Rezoning Transportation Analysis

Petition Number: #2022-126

Revision Log:

Date	Description
12-29-22	First Review (TM)
01-24-23	Second Review (DR)
02-23-23	Third Review (DR)
03-22-23	Fourth Review (DR)

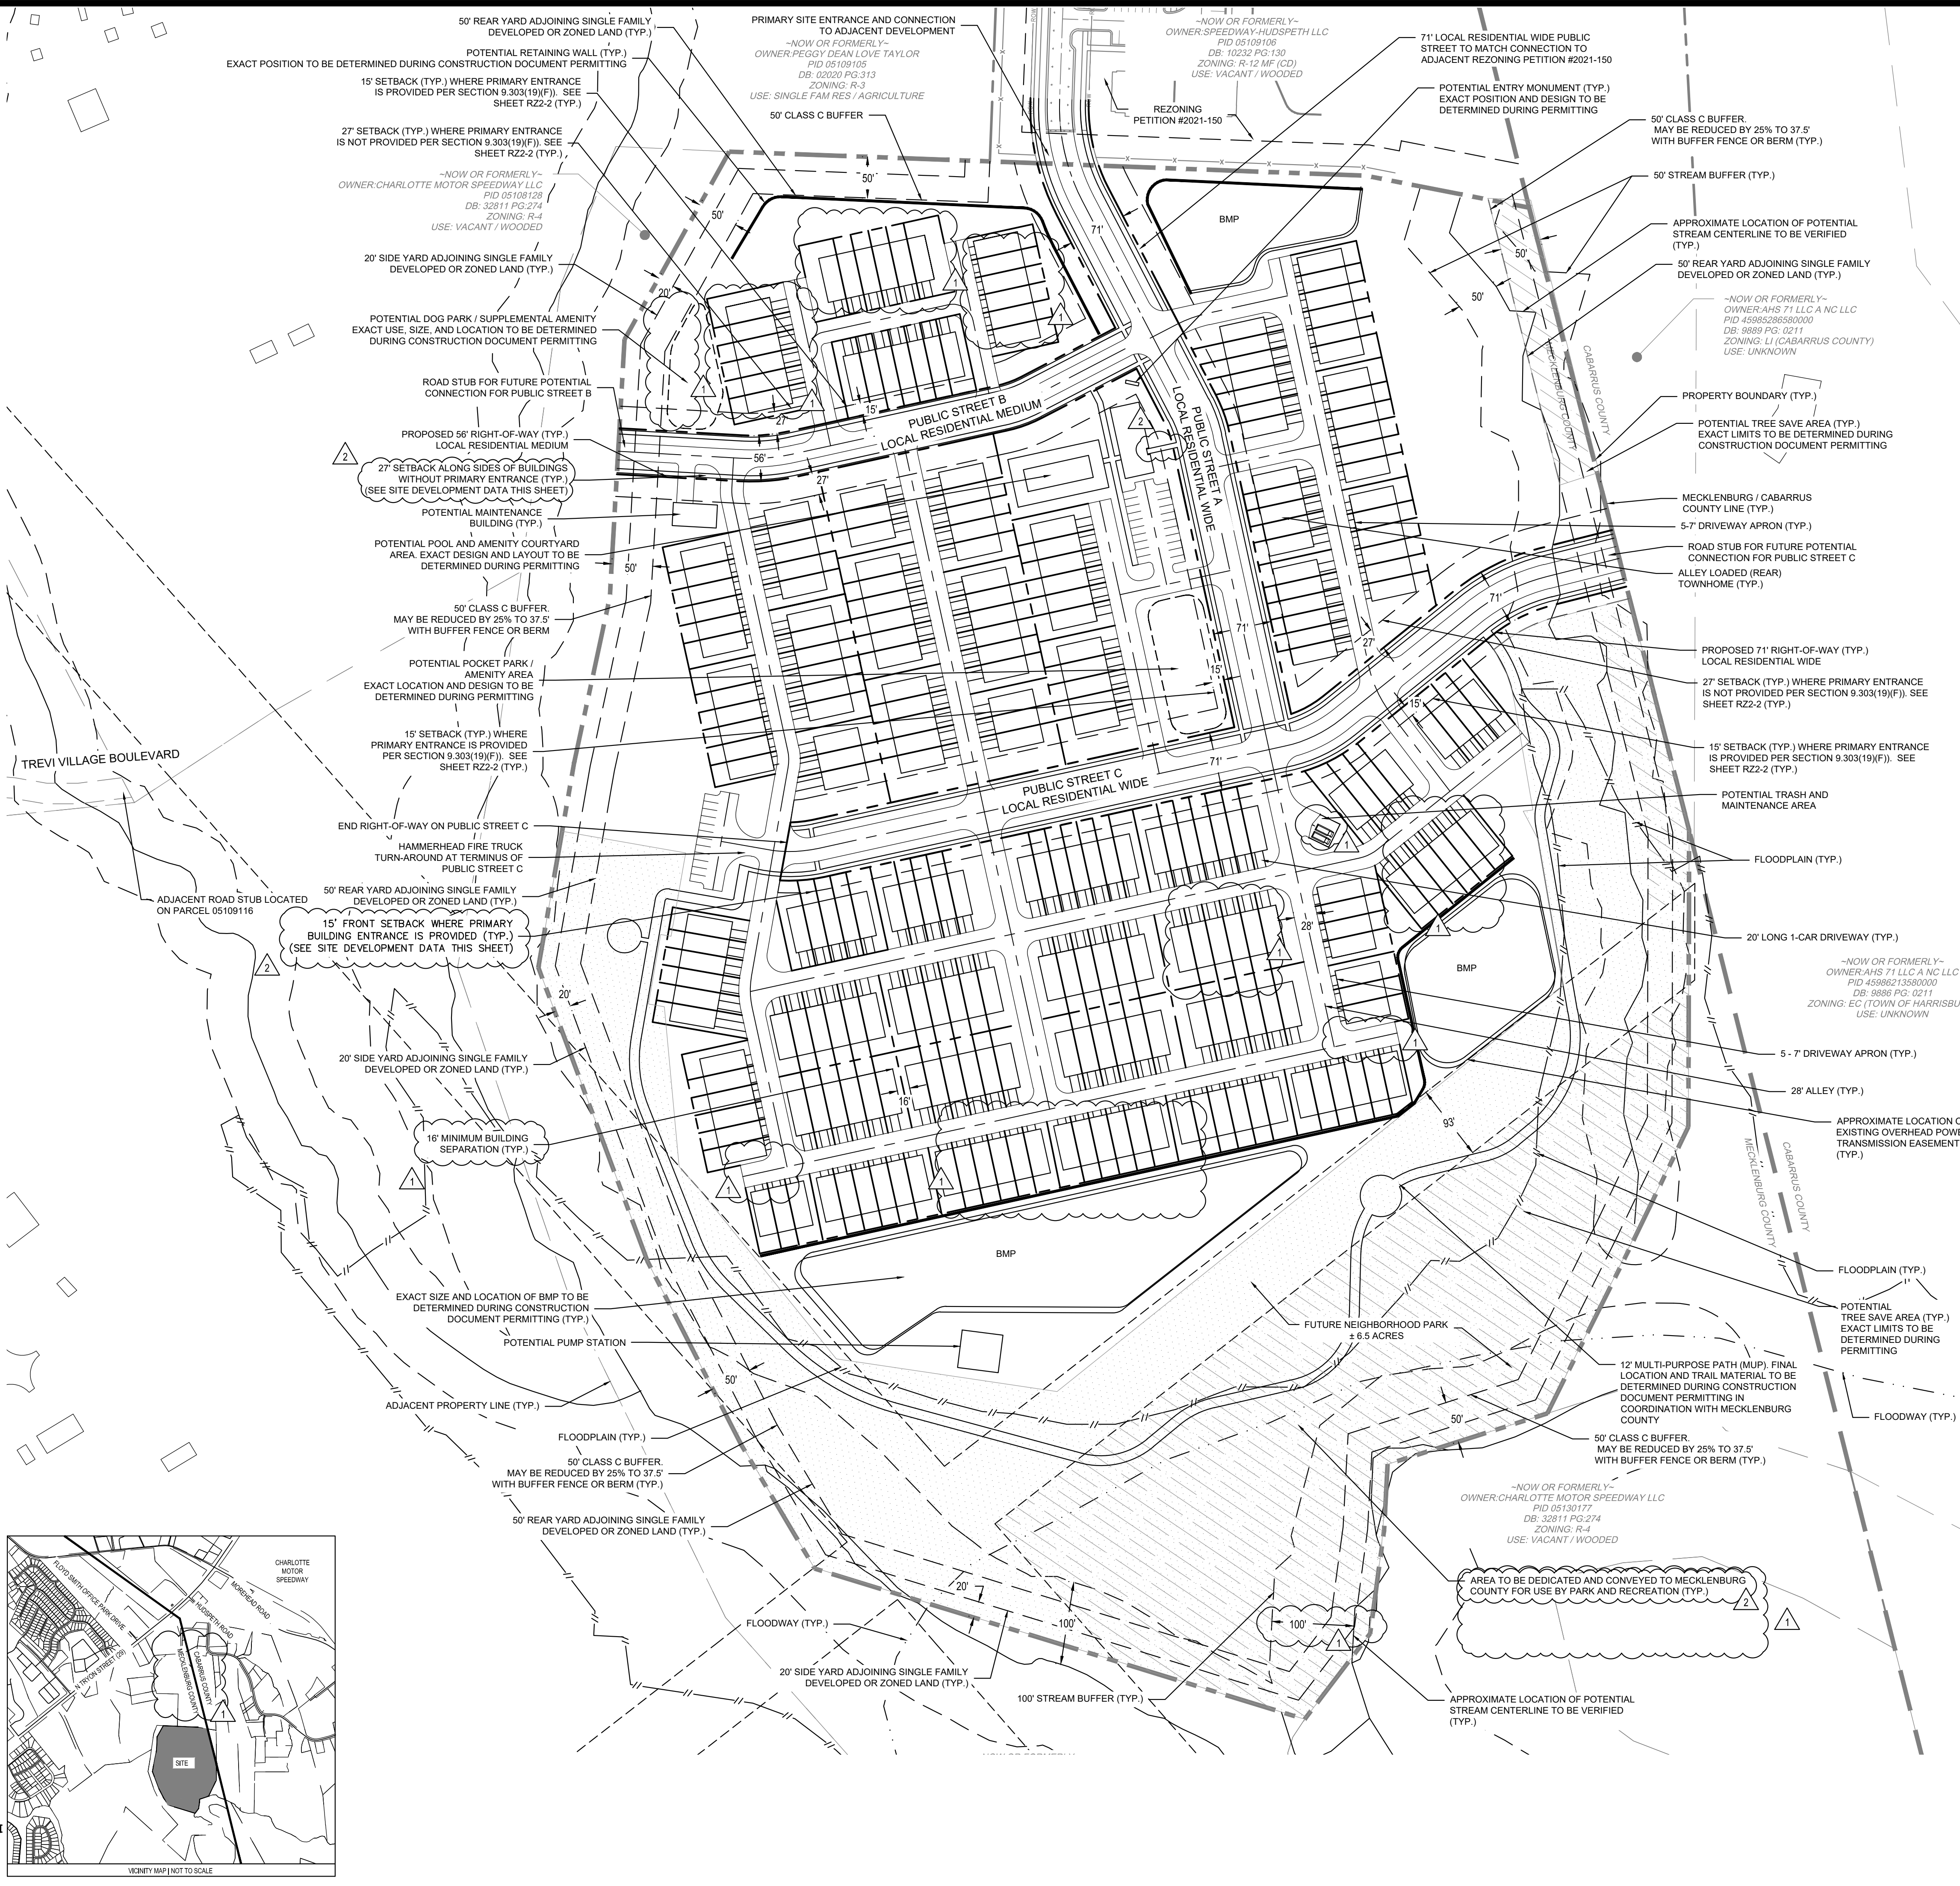
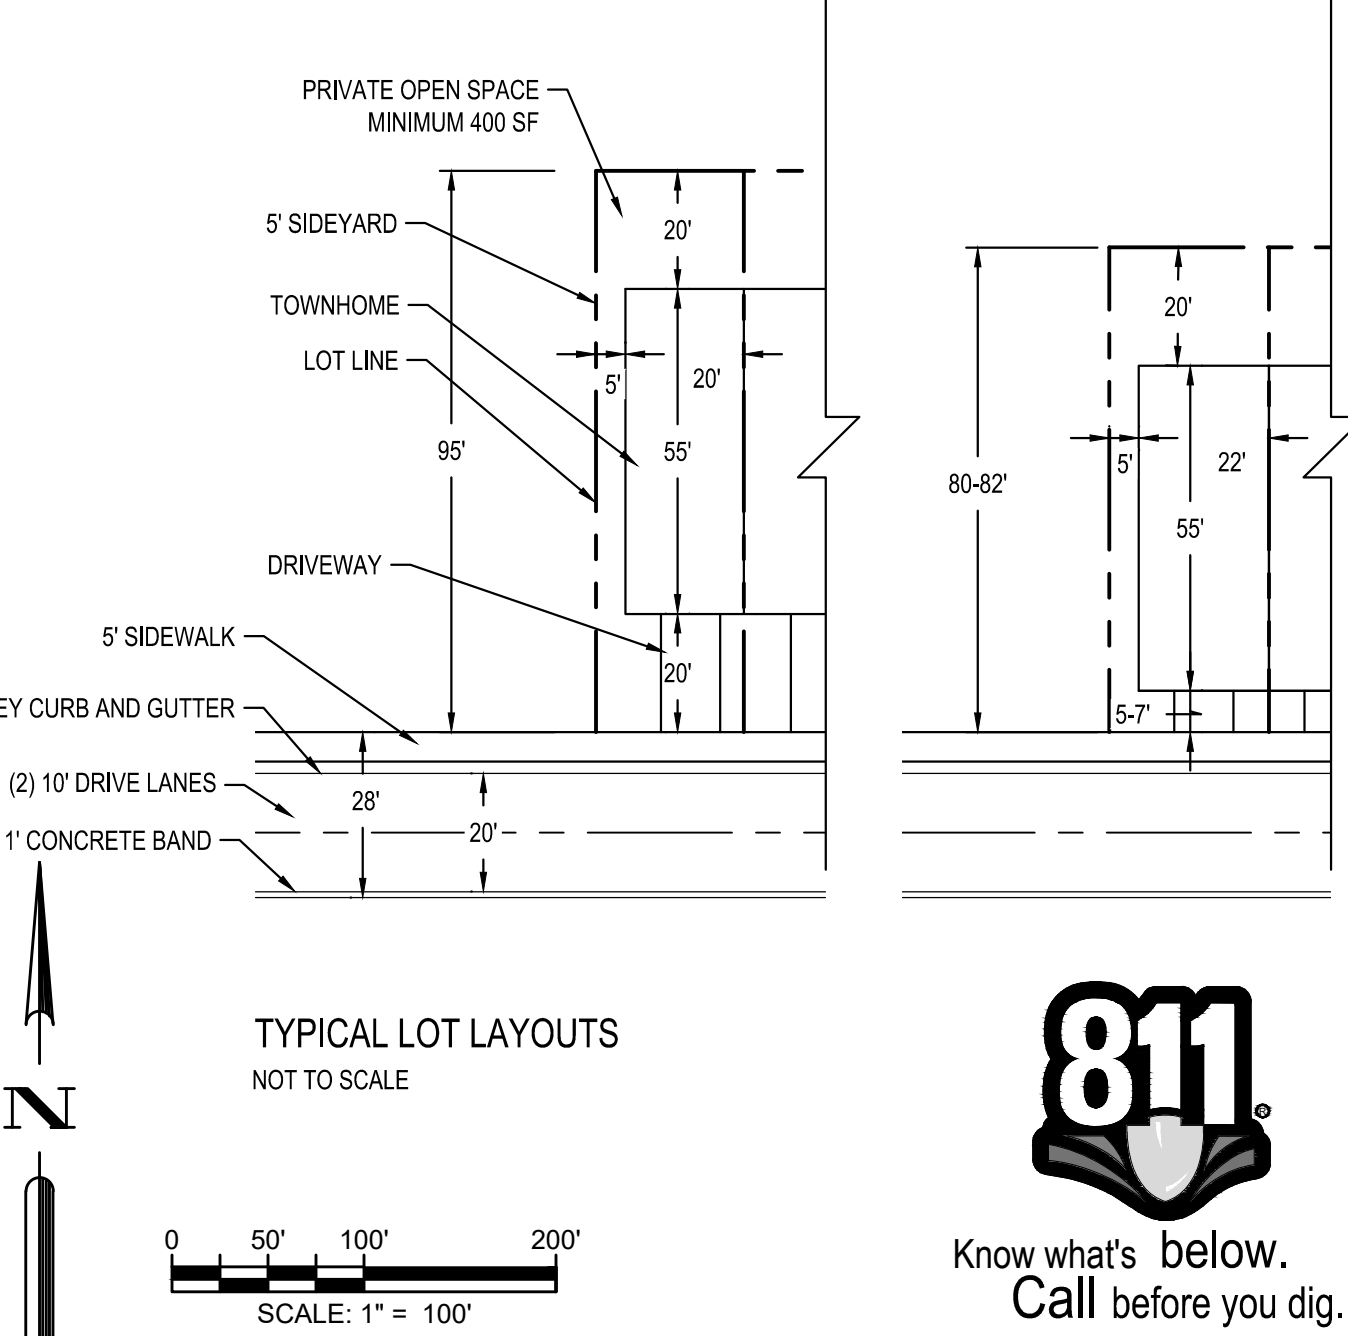
Clarifying comment from 1/24/2023: Add CLDSM roadway typical section for Local Residential Wide (CLDS U-03A) to sheet 2.
